Subject: FAO Robert Major re Consultation on Planning Application 3/2016/0146 Old Row Whalley Road Barrow BB7 9AZ

Planning Application 3/2016/0146

Outline application with all matters reserved for residential development of 23 dwellings, with access, parking and associated landscaping following demolition of nos.23 and 25 Old Row

drawing: **PROPOSED SITE LAYOUT**

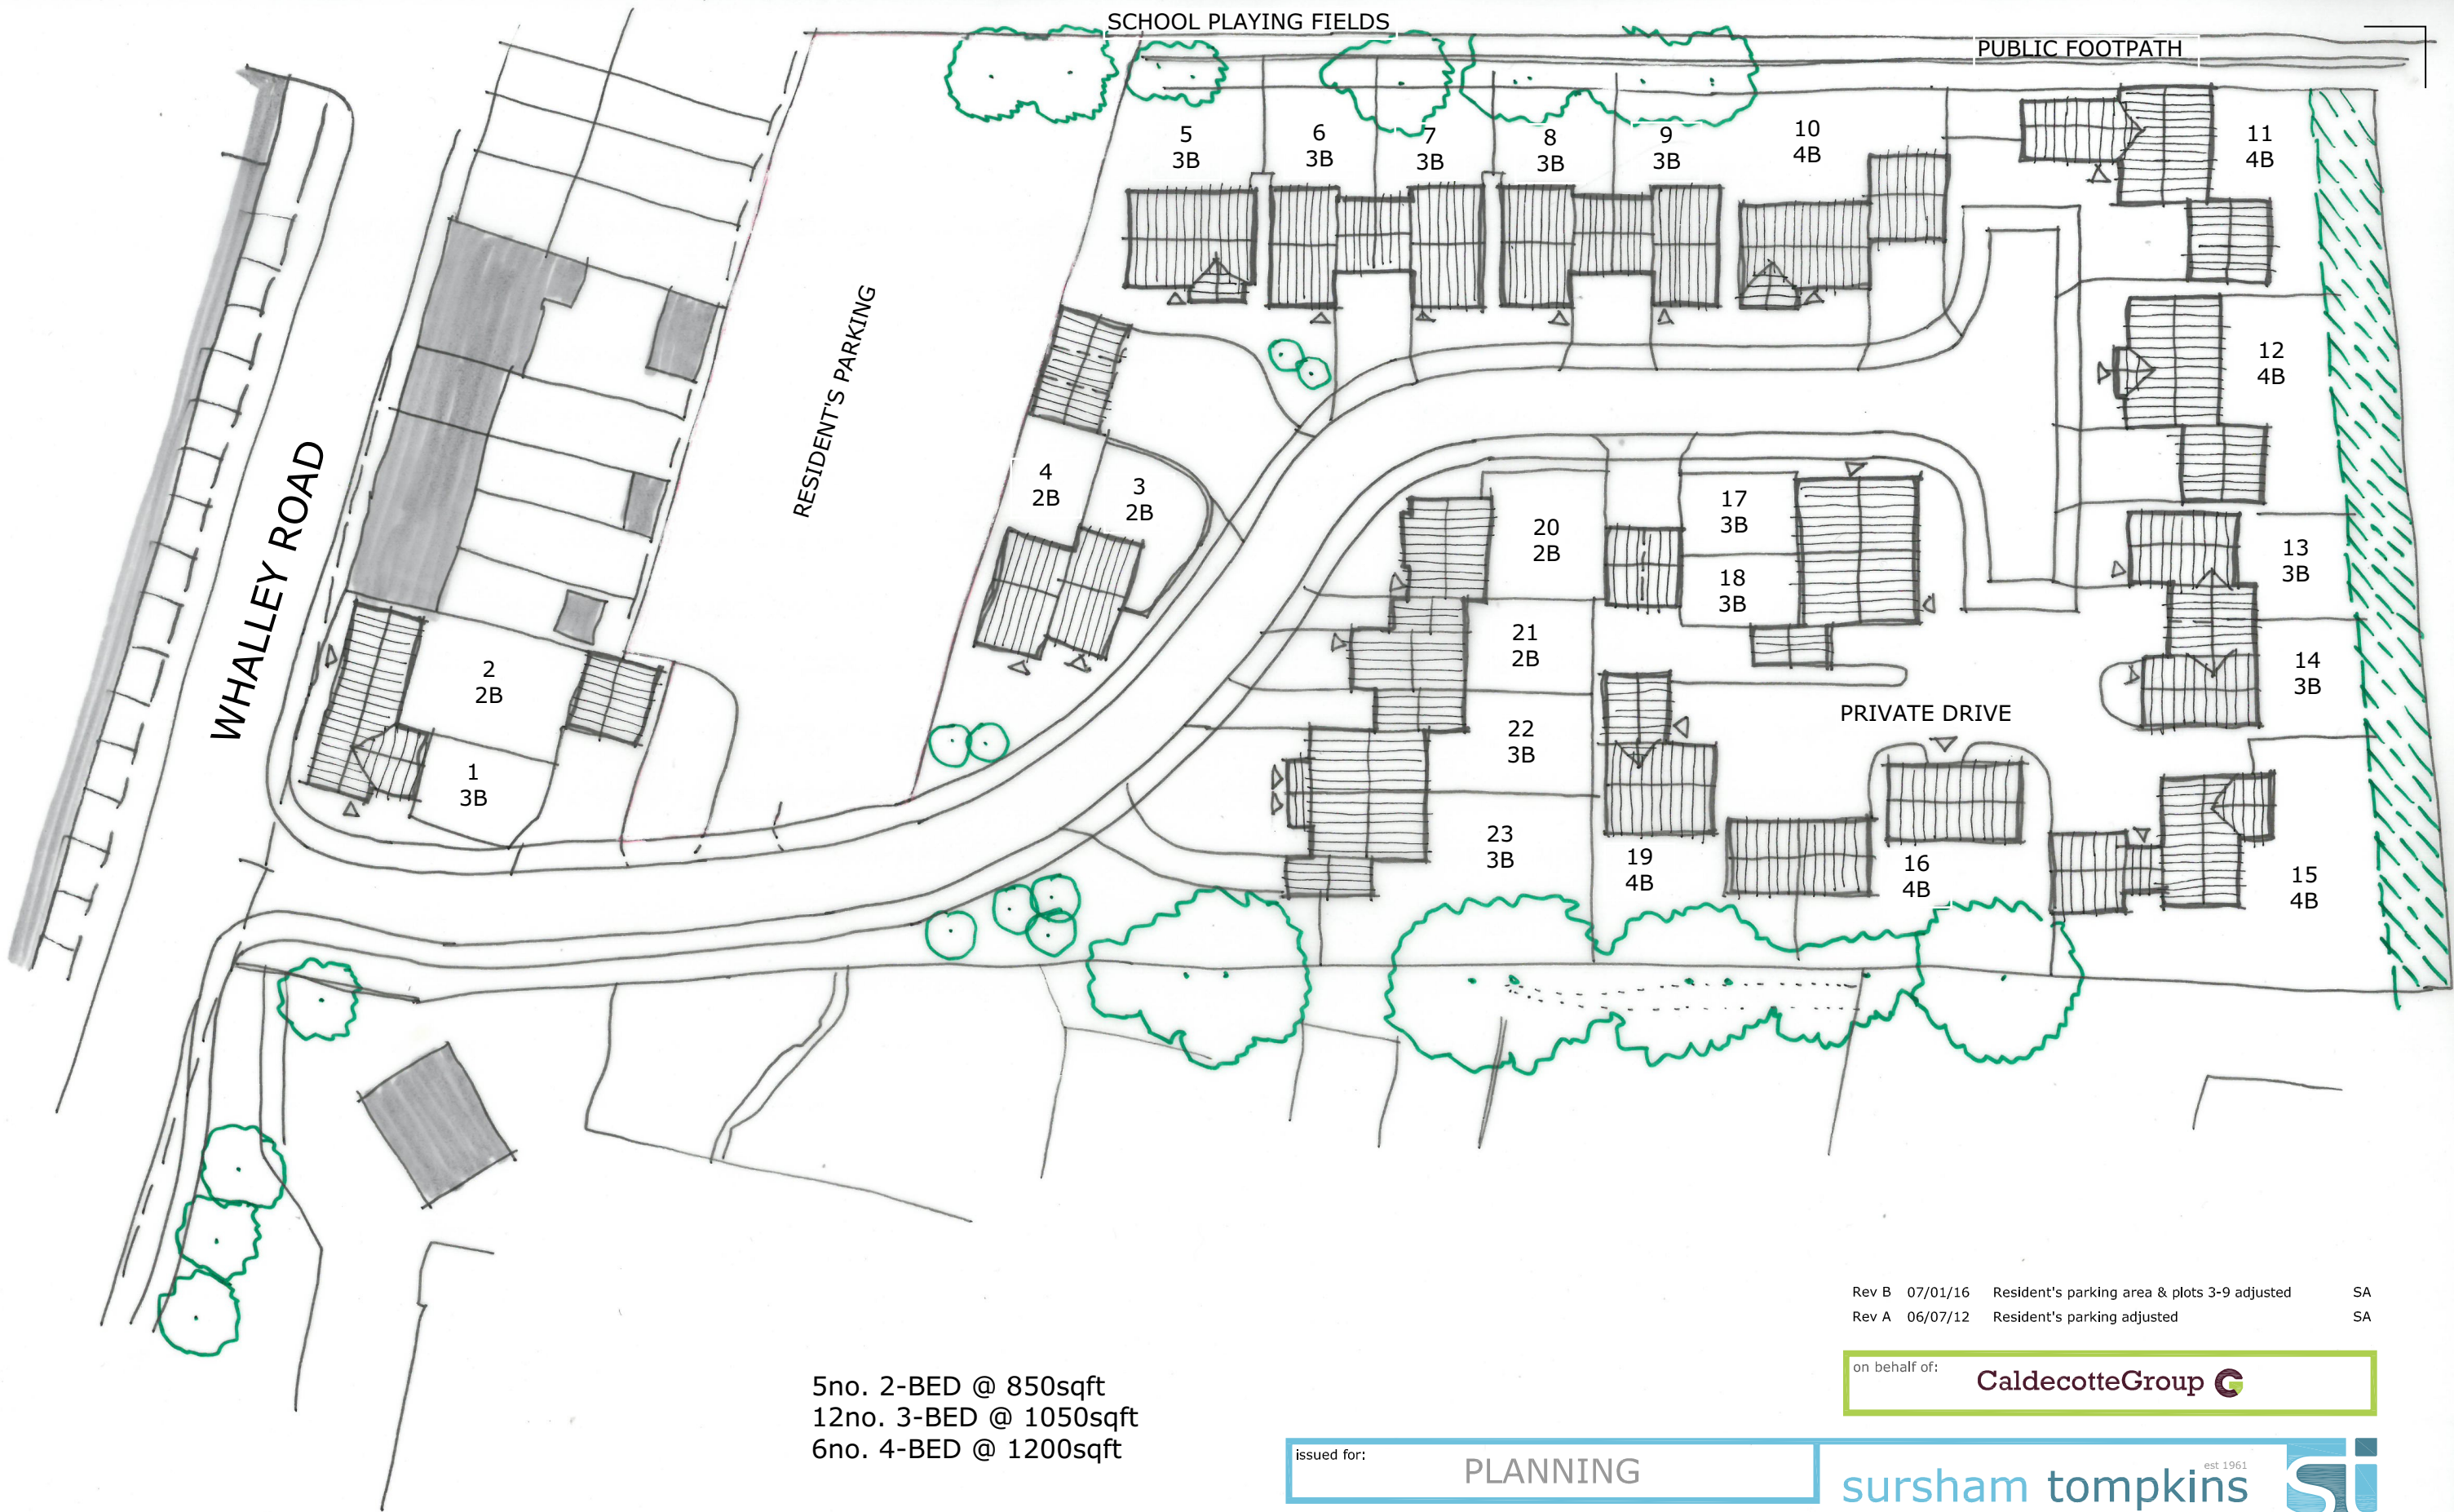
- Part of the proposed site has been incorporated into the Printworks site. As previously recommended by LCC Highways Department, could this development be accessed via the roundabout on the A59 rather than from Whalley Road? A similar plan was approved for the nearby Barrow Brook development and this has been successful in limiting traffic congestion and ensuring residents' safety.

- The Parish Council notes that the existing car park to the rear of Old Row will remain intact but there is no further information and the plans for this area must be clarified. For example, who will own the car park and who will maintain it? Residents from Old Row require access to the rear of their properties for waste removal etc and this access needs to be formalised in a legal agreement. The car park is currently in a very poor state of repair and will require re-surfacing and a dropped pavement should planning approval be granted.

- The developers have stated that demolition of 23-25 Old Row is required for access purposes. However, it is noted that replacement dwellings will be erected on the footprint of these buildings and it is unclear exactly how access to the site will be improved.
- It must be remembered that neglect of a property is NOT a justification for its demolition, as detailed in NPPF paragraphs 126-141. Perhaps, rather than demolishing it, the property could be turned back into a Public House for the growing population, or converted into a home, with provision made to preserve the outside appearance of the building? This would ensure that the unified appearance of the properties on Whalley Road is maintained and the history of Barrow is preserved.

- The public footpath that runs through the site must be maintained and protected.
